WEST SUSSEX COUNTY COUNCIL CONSULTATION

TO:	Arun District Council FAO: Mr. S. Davis
FROM:	WSSC – Highways Authority
DATE:	7 November 2025
LOCATION:	Land Adjacent to Woodgate Nurseries Lidsey Road Aldngbourne PO20 3SU
SUBJECT:	AL/93/25/DOC Approval of details reserved by condition imposed under reference AL/129/21/OUT relating to condition 14 - construction & environmental management plan.
DATE OF SITE VISIT:	21 October 2025
RECOMMENDATION:	Advice

Dwg No: H9390-SEP-01

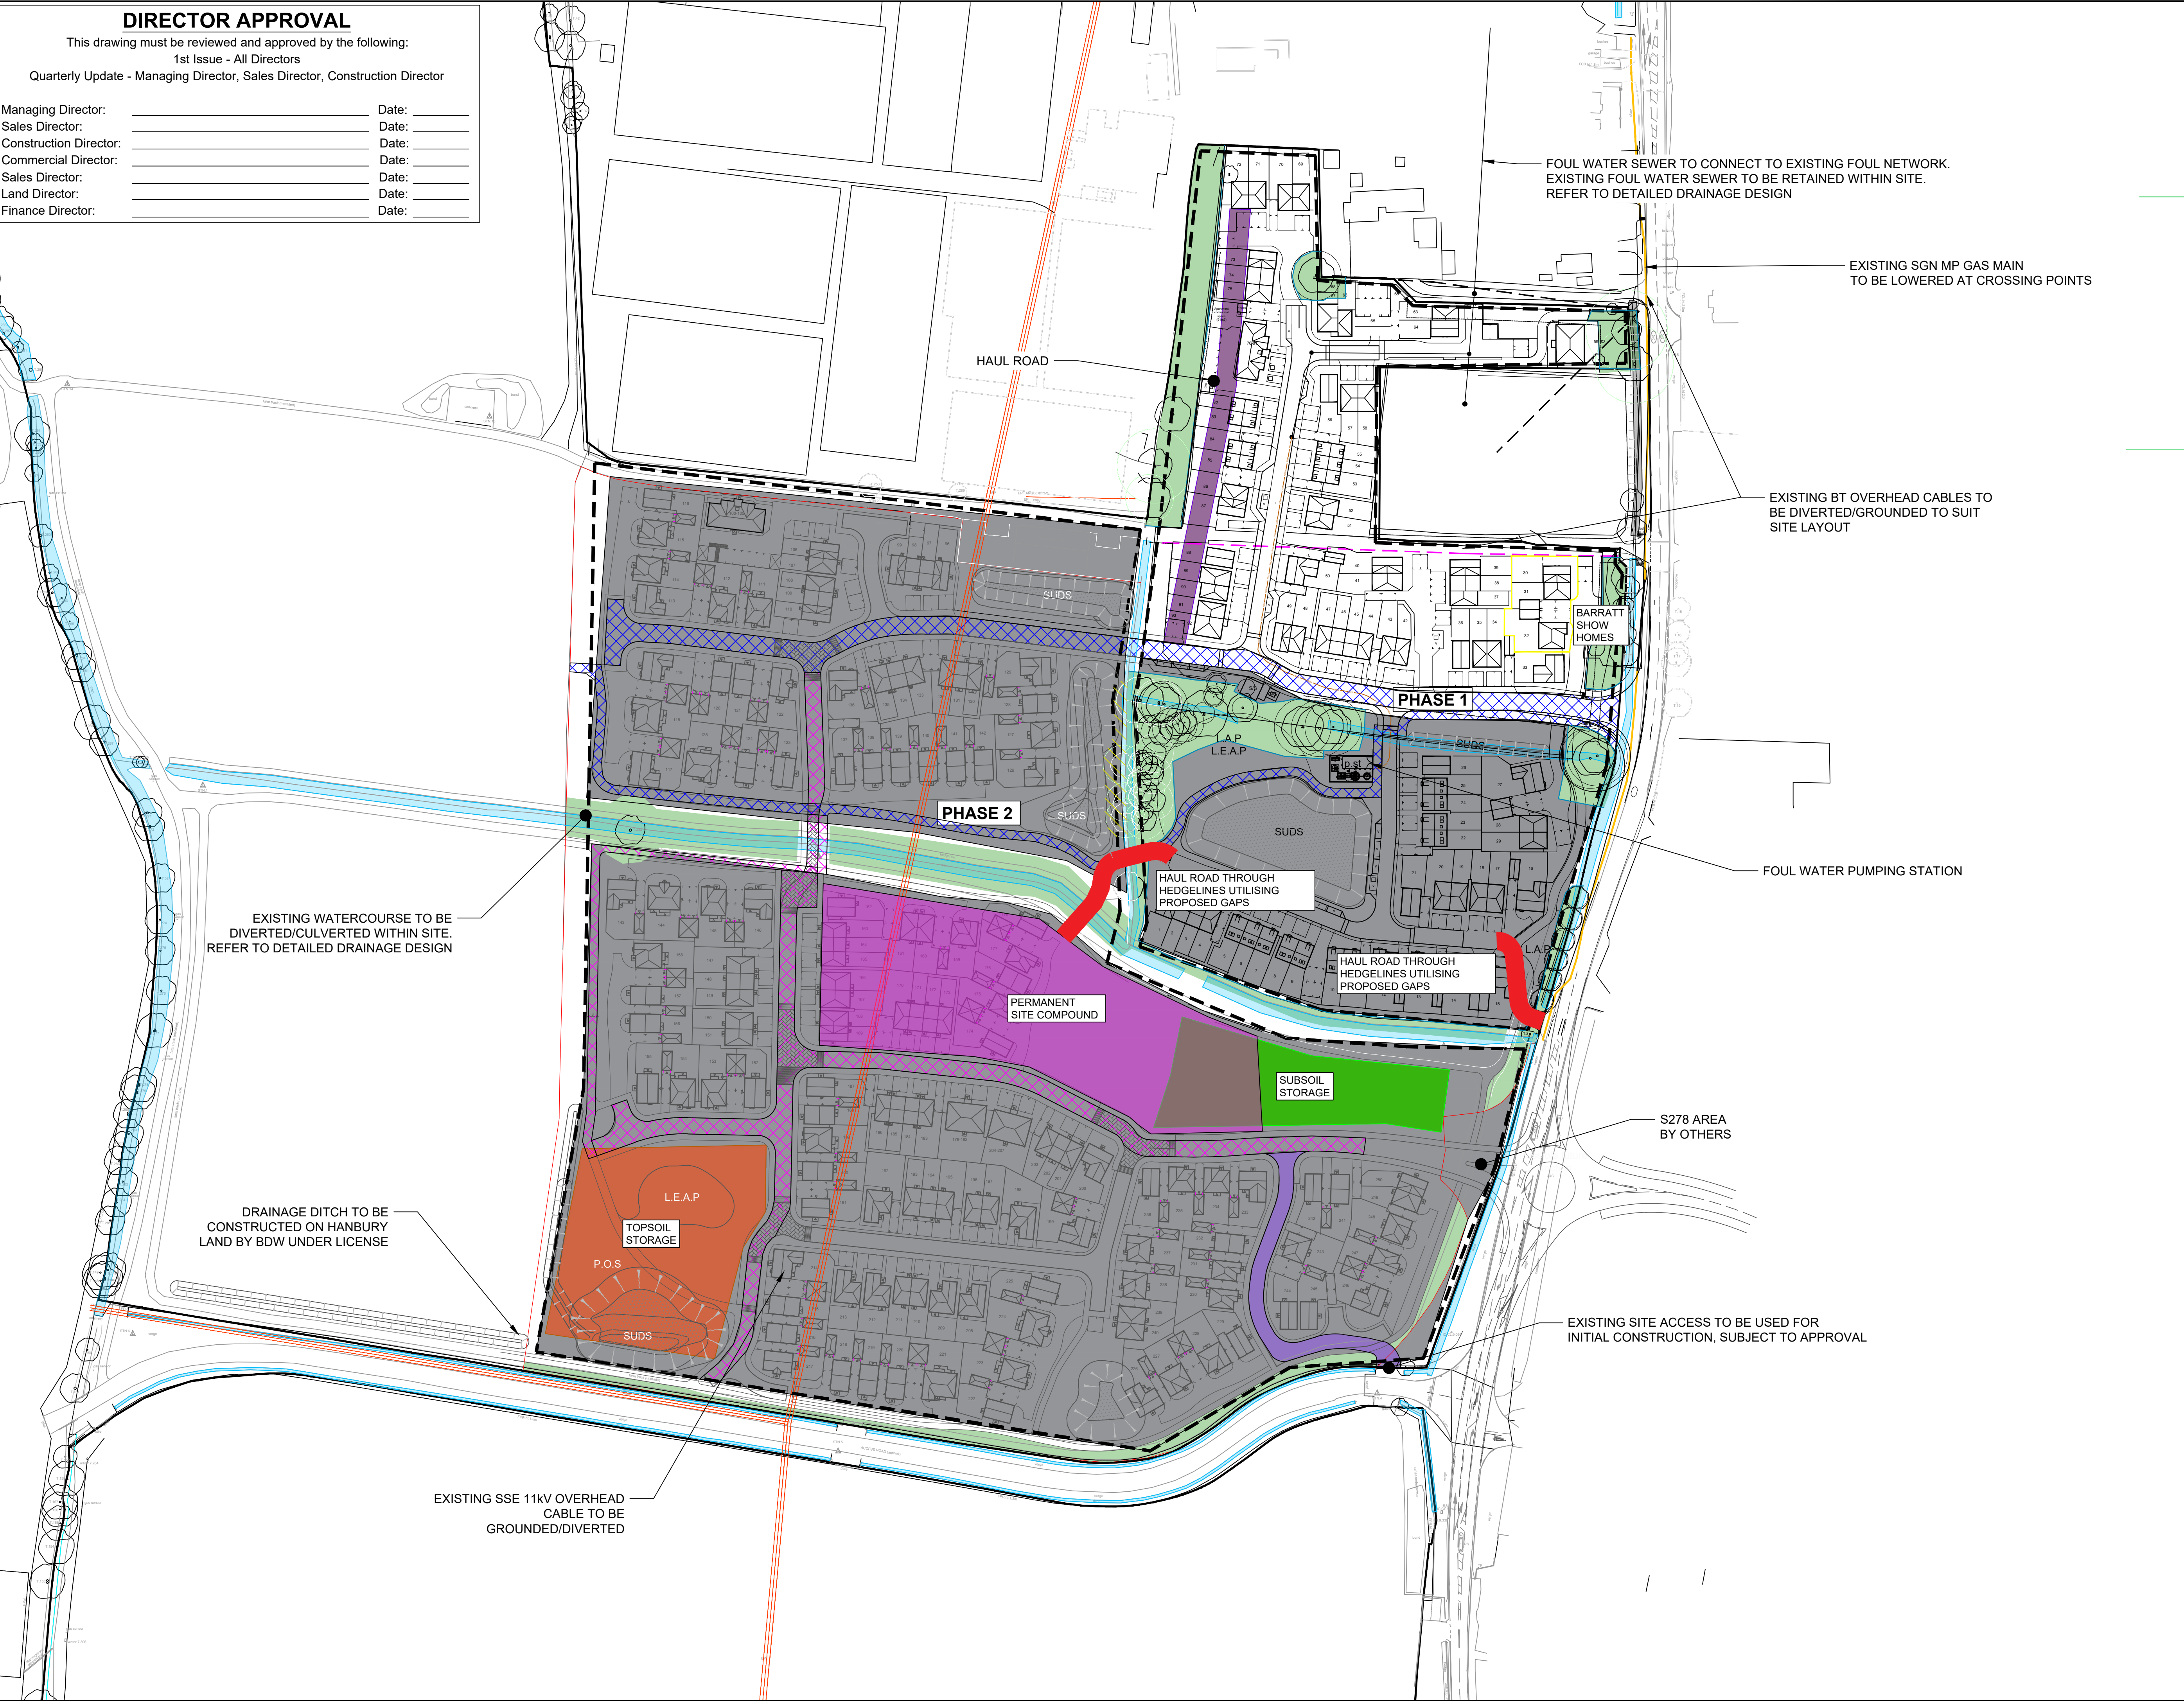
In its previous response, the Highway Authority identified that a plan still showed one of the possible construction access points being off the former Lidsey Landfill access found south of the application site. Although the text in the CEMP (Revision 'D') removed reference to it, a plan in the document (Drawing No. H9390-SEP-01) still showed it.

In the latest version of the CEMP (Rev E), the applicant has confirmed that the 'Execution Plan' has been amended to remove all references to use of the existing site access leading off the Lidsey Landfill track/road.

Haul Road
Visibility Splays
Scale 1:1000@A1

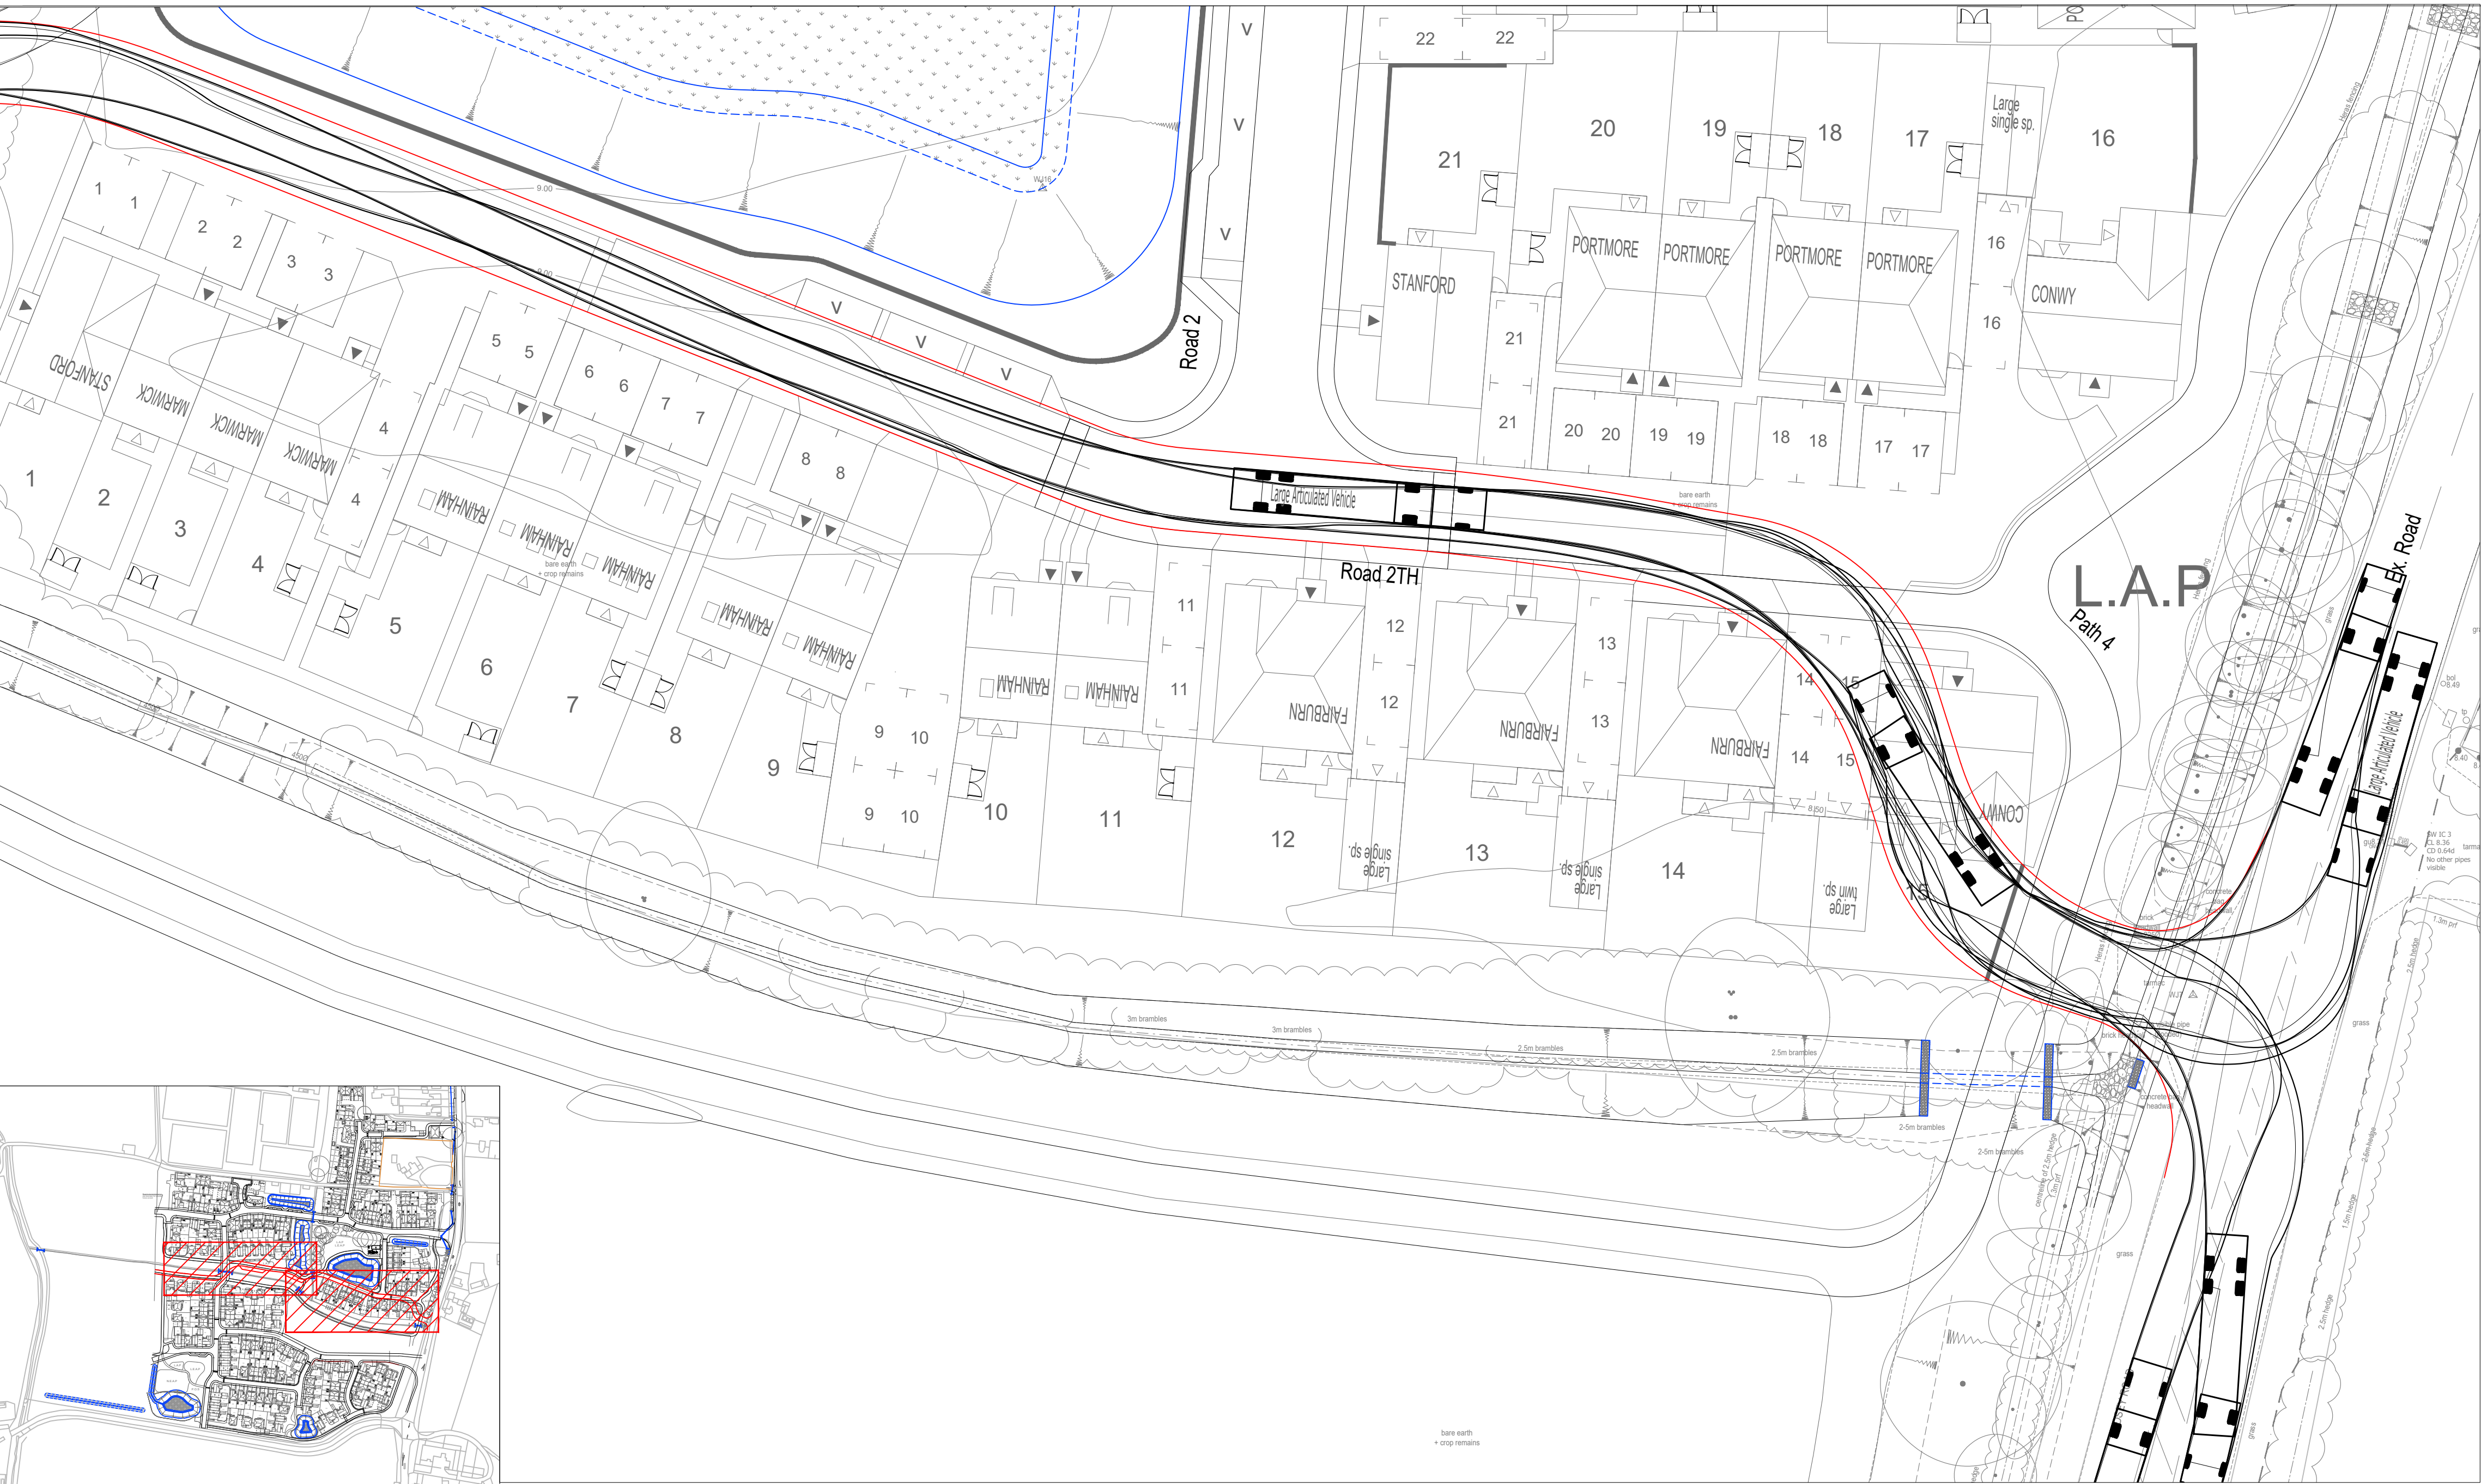
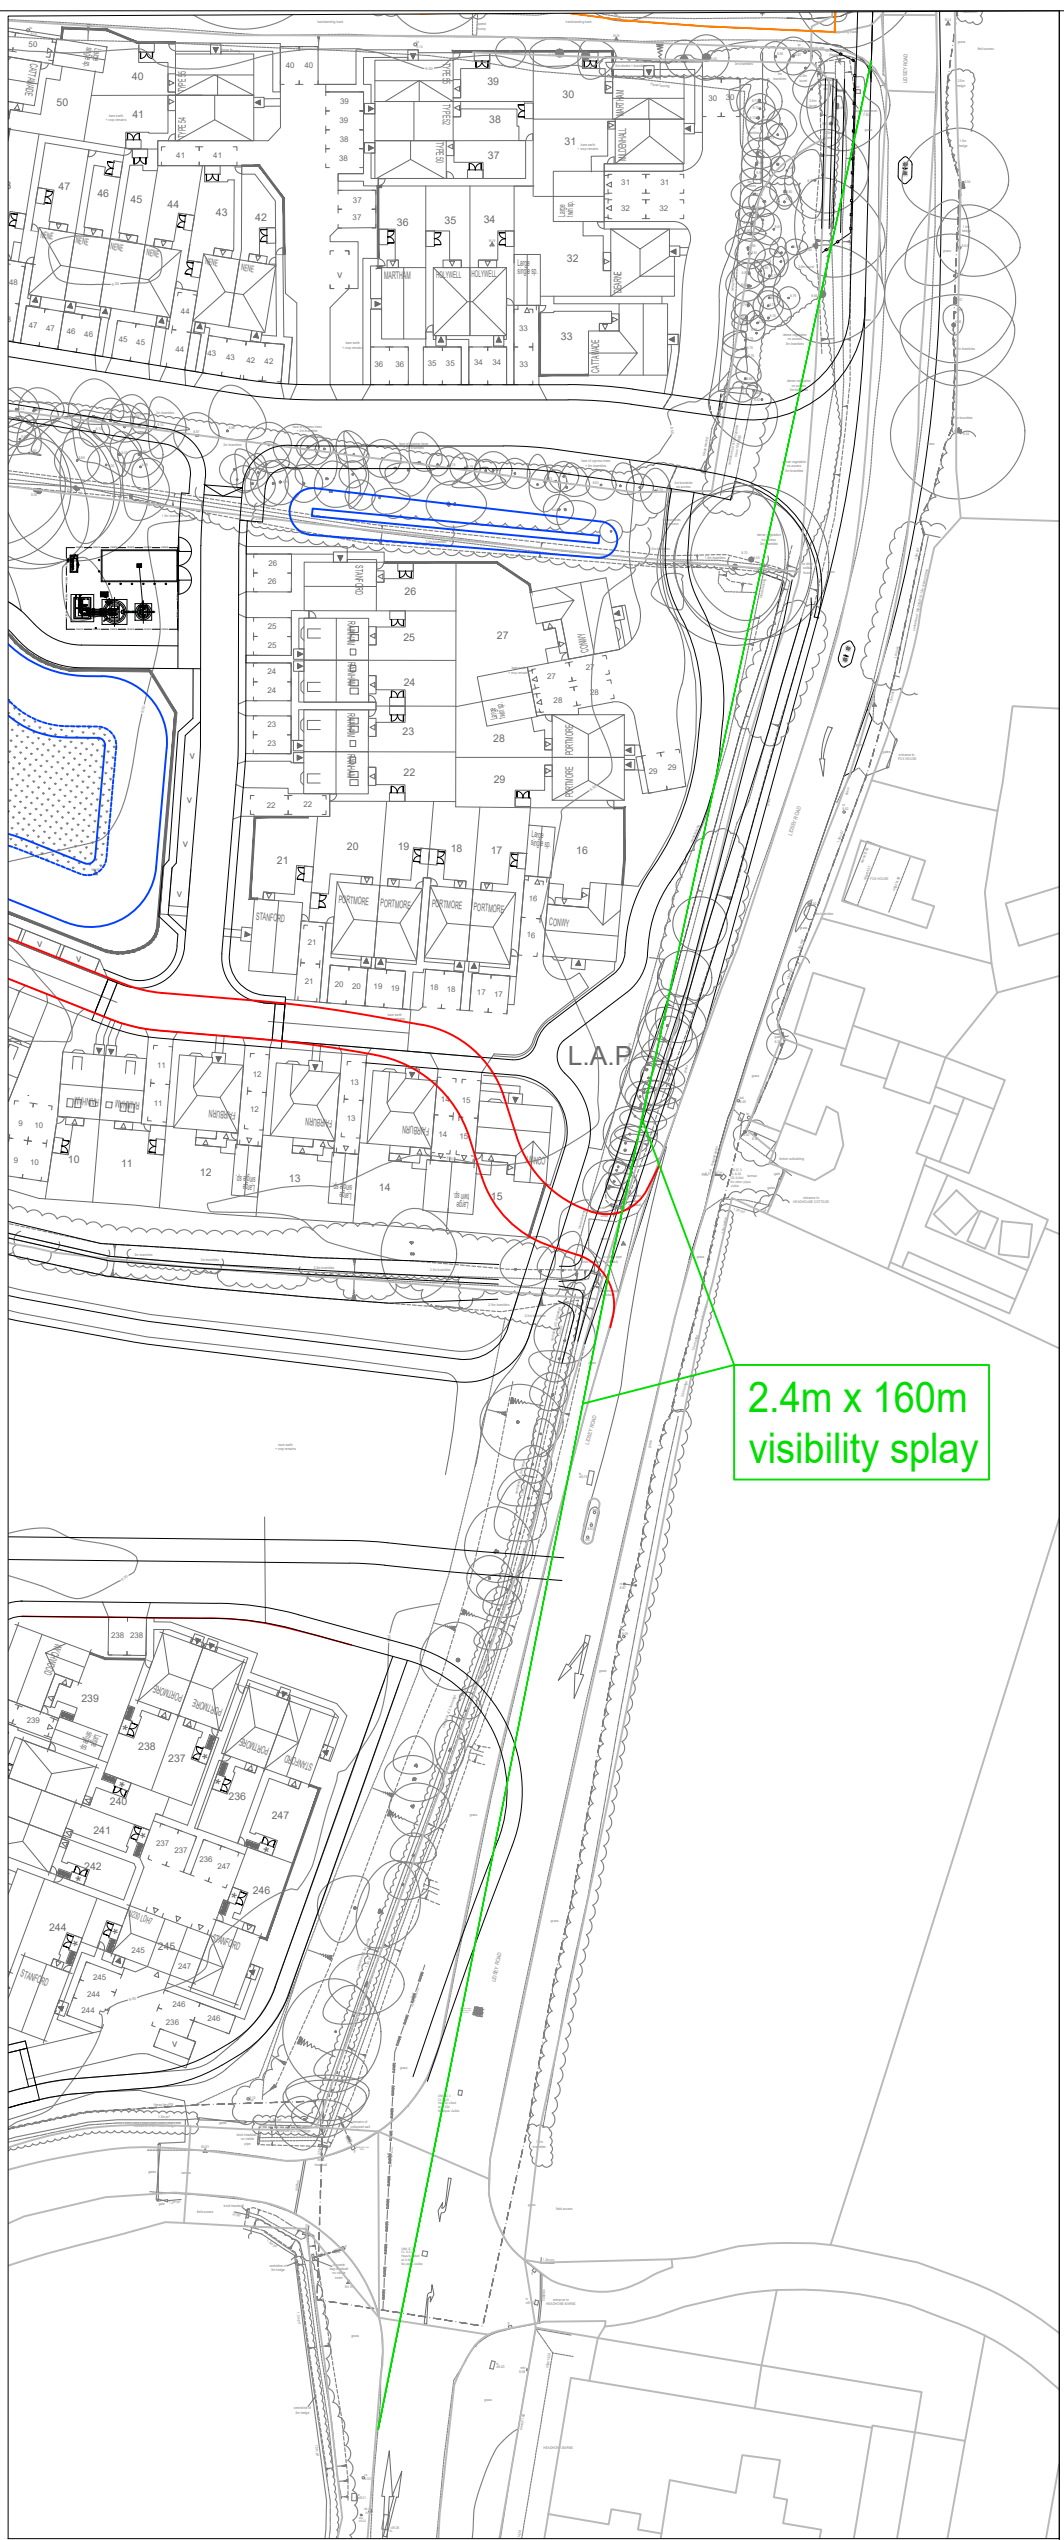
Comments re. wheel washing, road sweeping and maintenance of visibility splays from both access points still stand for the accesses proposed to be used.
